**SUNDERLAND CITY COUNCIL'S RESPONSE TO THE DRAFT
DEVELOPMENT CONSENT ORDER – DOCUMENT REFERENCE SCC 1**

DCO PROVISION	COMMENT
2. "the engineering drawings and sections"	<p>The following drawings submitted by the applicant as part of this DCO submission have been reviewed by SCC.</p> <p>It is noted that the drawing status is to support the application, and as such are not full detailed design drawings.</p> <p>The drawings listed below are considered acceptable in principle. However, comments are provided below to assist with future design and drawing revisions.</p> <p>Location Plan: TR010024/APP/2.1 Rev 0 Scheme Layout Plan: TR010024/APP/2.2 Rev 0 Engineering Drawings and Sections: TR010024/APP/2.6 Rev 0</p> <p>Engineering Drawings - Highways General Arrangement – APFP Regulation 5(2)(o) – Sheet 1 of 2, TR010024/APP/2.6.1(A)</p> <p>Engineering Drawings - Highways General Arrangement – APFP Regulation 5(2)(o) – Sheet 2 of 2' TR010024/APP/2.6.1(B)</p> <p>Engineering Drawings - Highways Longitudinal Sections – APFP Regulation 5(2)(o) – Sheet 1 of 3, TR010024/APP/2.6.2(A)</p> <p>Engineering Drawings - Highways Longitudinal Sections – APFP Regulation 5(2)(o) – Sheet 2 of 3, TR010024/AP

Drawing title **ENGINEERING DRAWINGS STRUCTURES DRAWINGS & SECTIONS NON-MOTORISED USER OVERBRIDGE REGULATION 5(2)(o) & 6(2)**

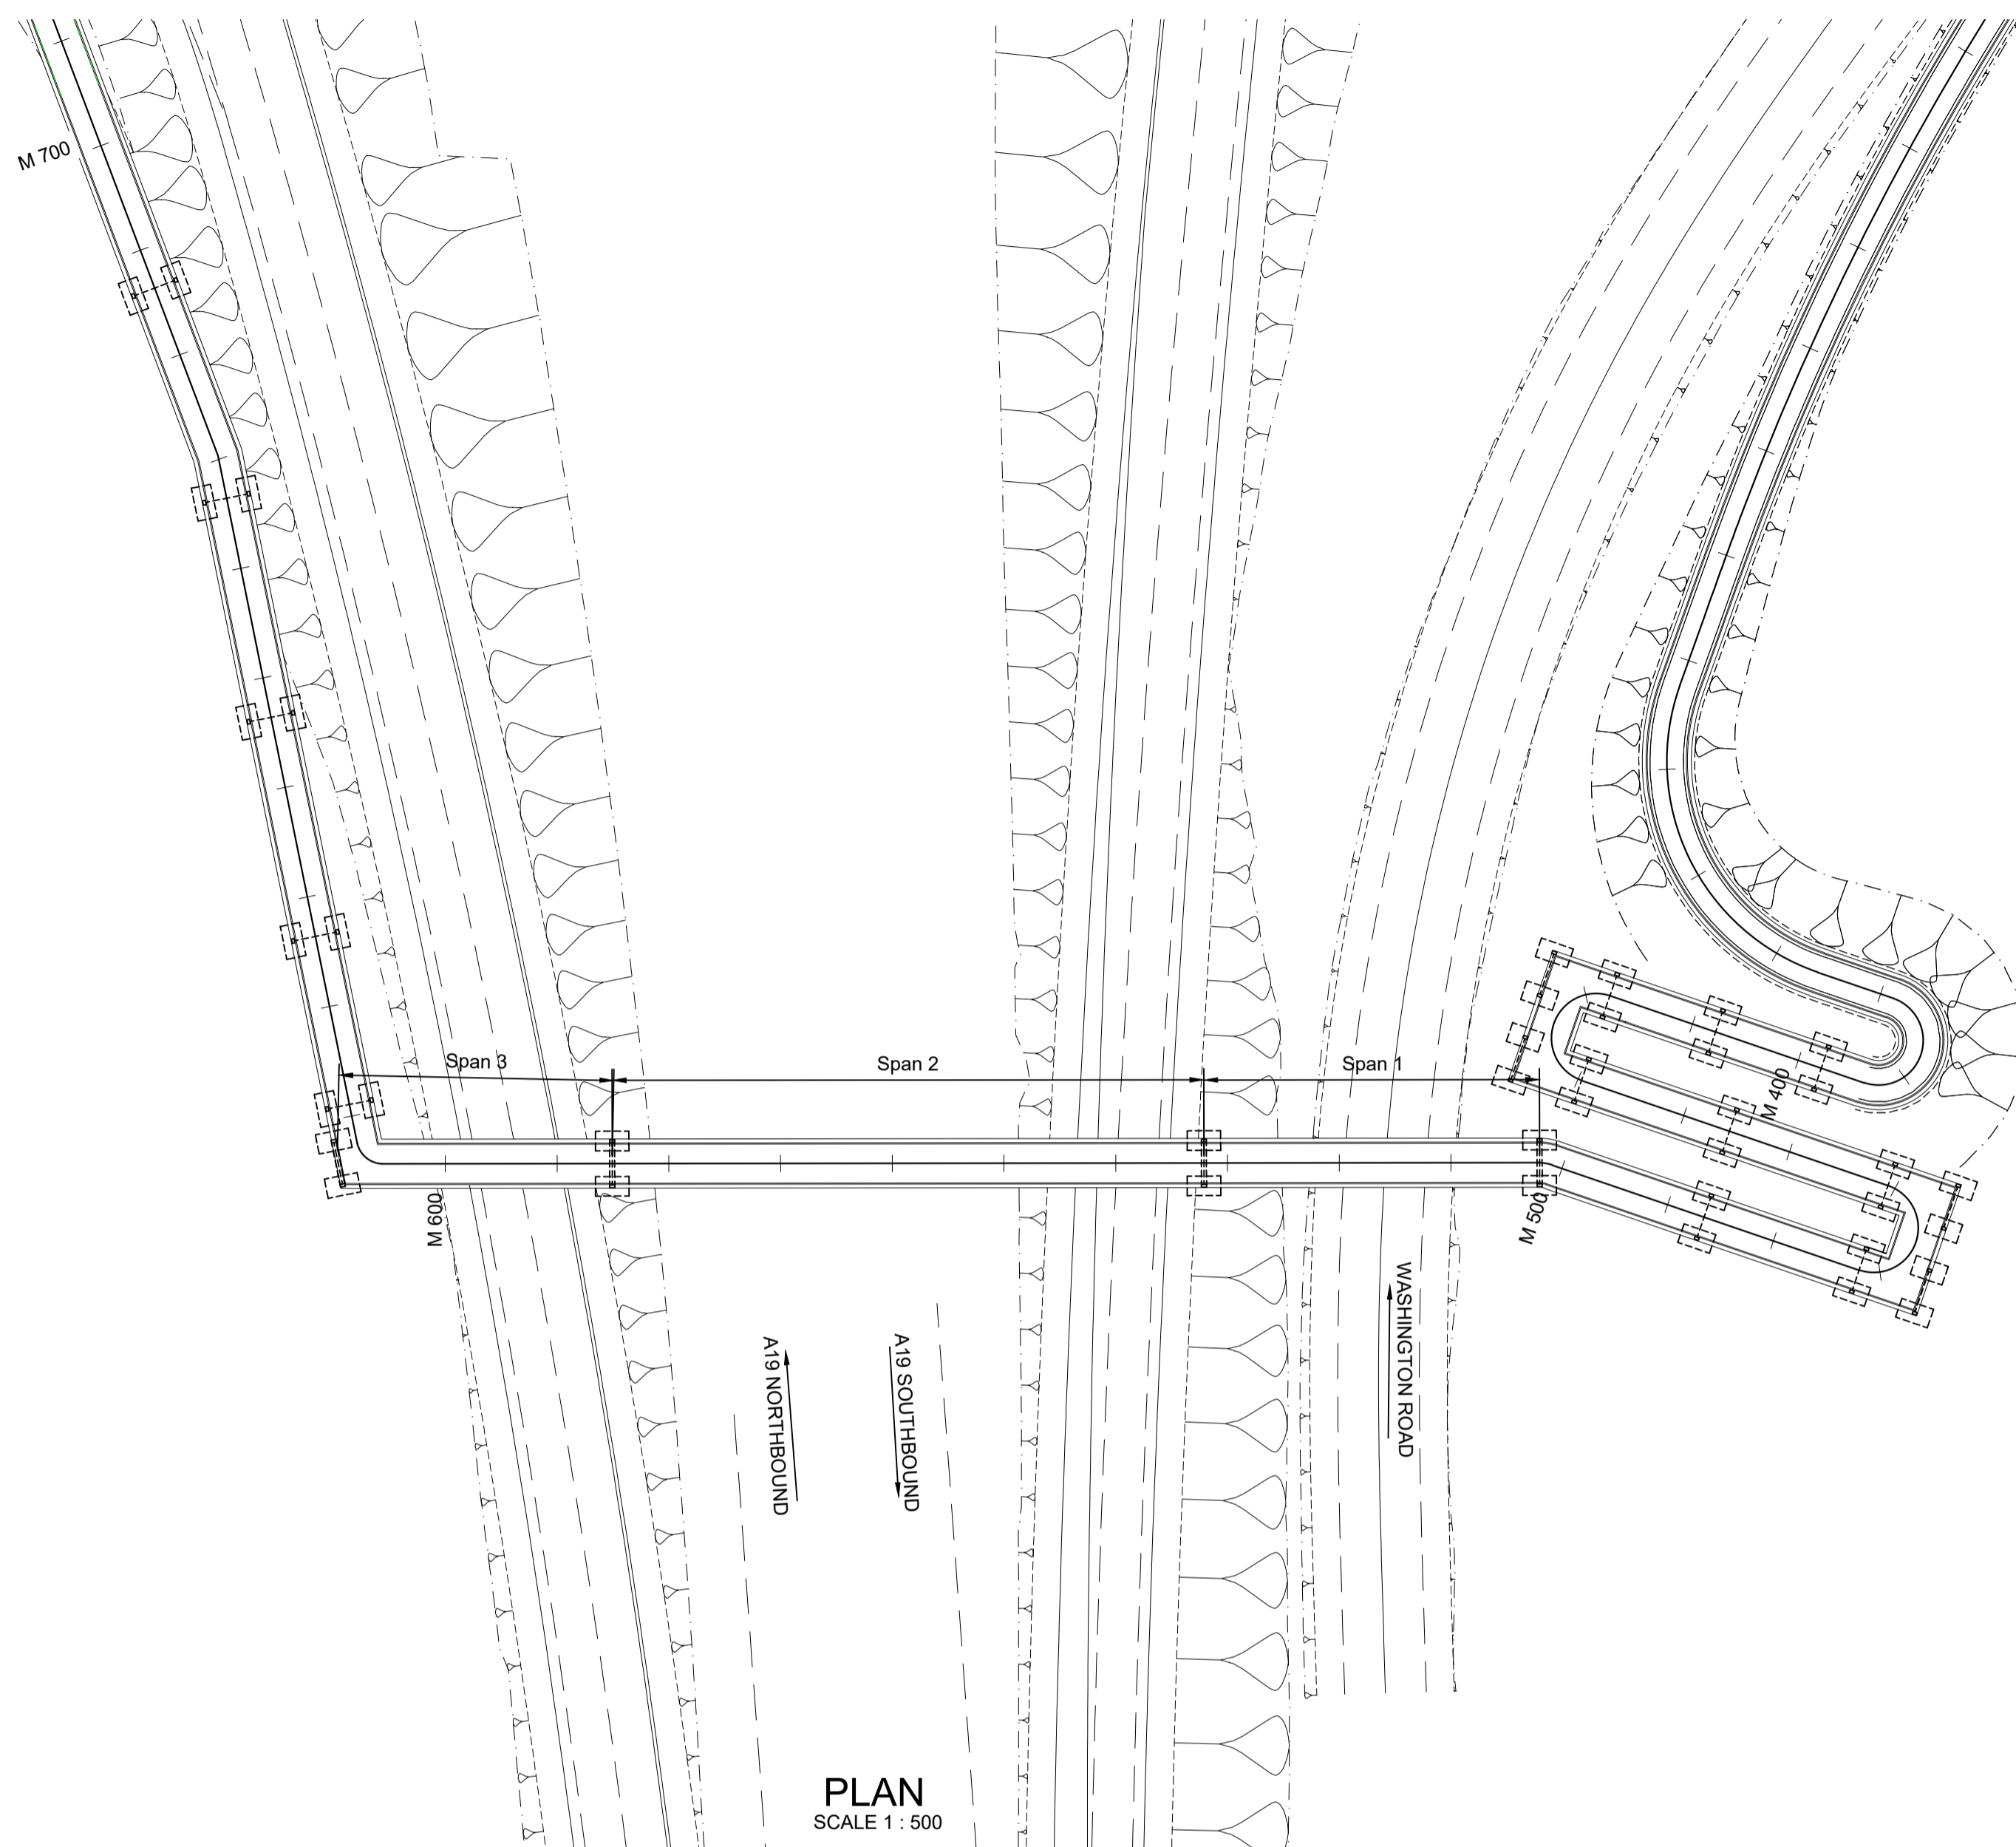
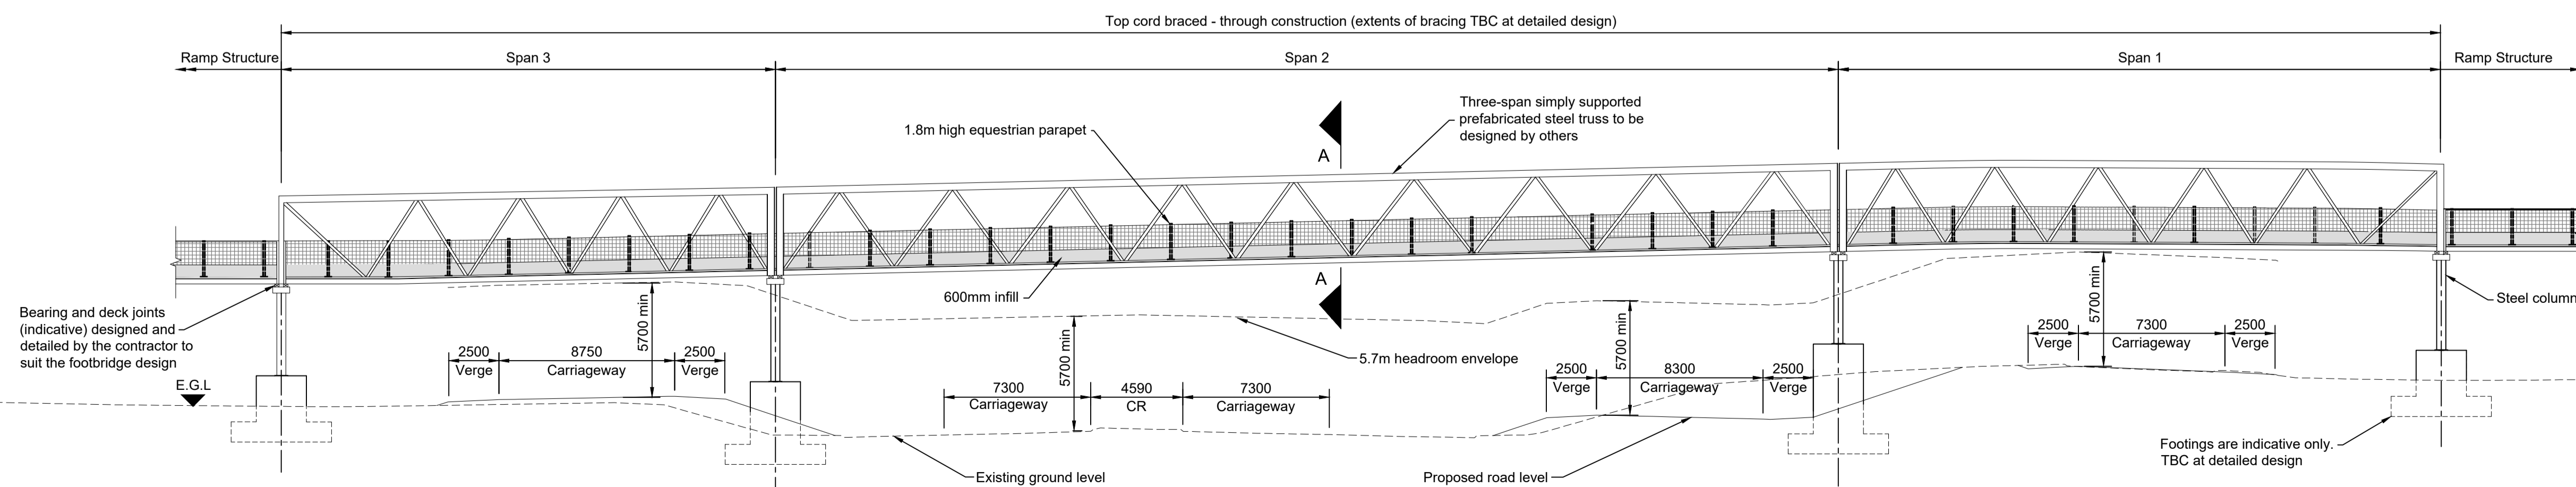
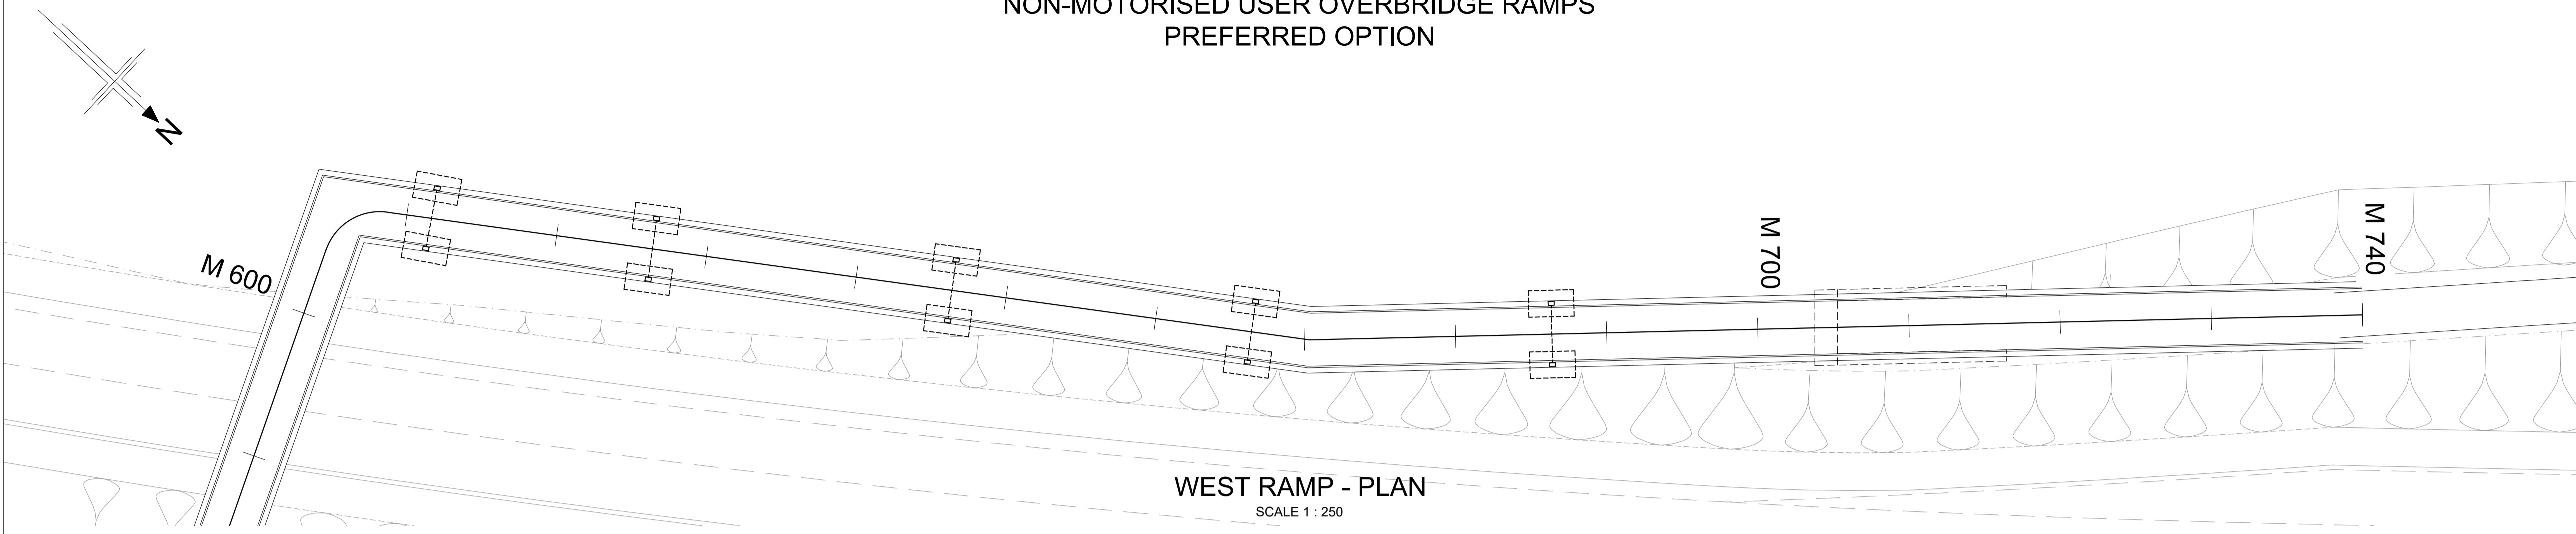
<p>based on Section A-A shown on drawing TR010024/APP/2.6.3(B).</p> <p>The same principle to apply for the future maintenance of the eastern /western approach ramp structures.</p> <p>Access control at either end at the start of the eastern and western approach ramps should be considered to deter access by other vehicle types. It is noted that this may change based on the applicant's proposal to change the location of the NMU crossing.</p> <p><u>SCC Comment 4 – It is noted that three highway drainage / pollution control ponds and associated drainage ditches are proposed on land to be acquired for the scheme -</u></p> <p>The adoption and future maintenance of the proposed attenuation ponds and drainage ditches to be dealt with by a Side Agreement.</p> <p><u>SCC Comment 5 - The A1290 pond may fall within land required for the DCO for IAMP TWO highway improvements -</u></p> <p>This should be clarified by the applicant in discussion with IAMP LLP.</p>
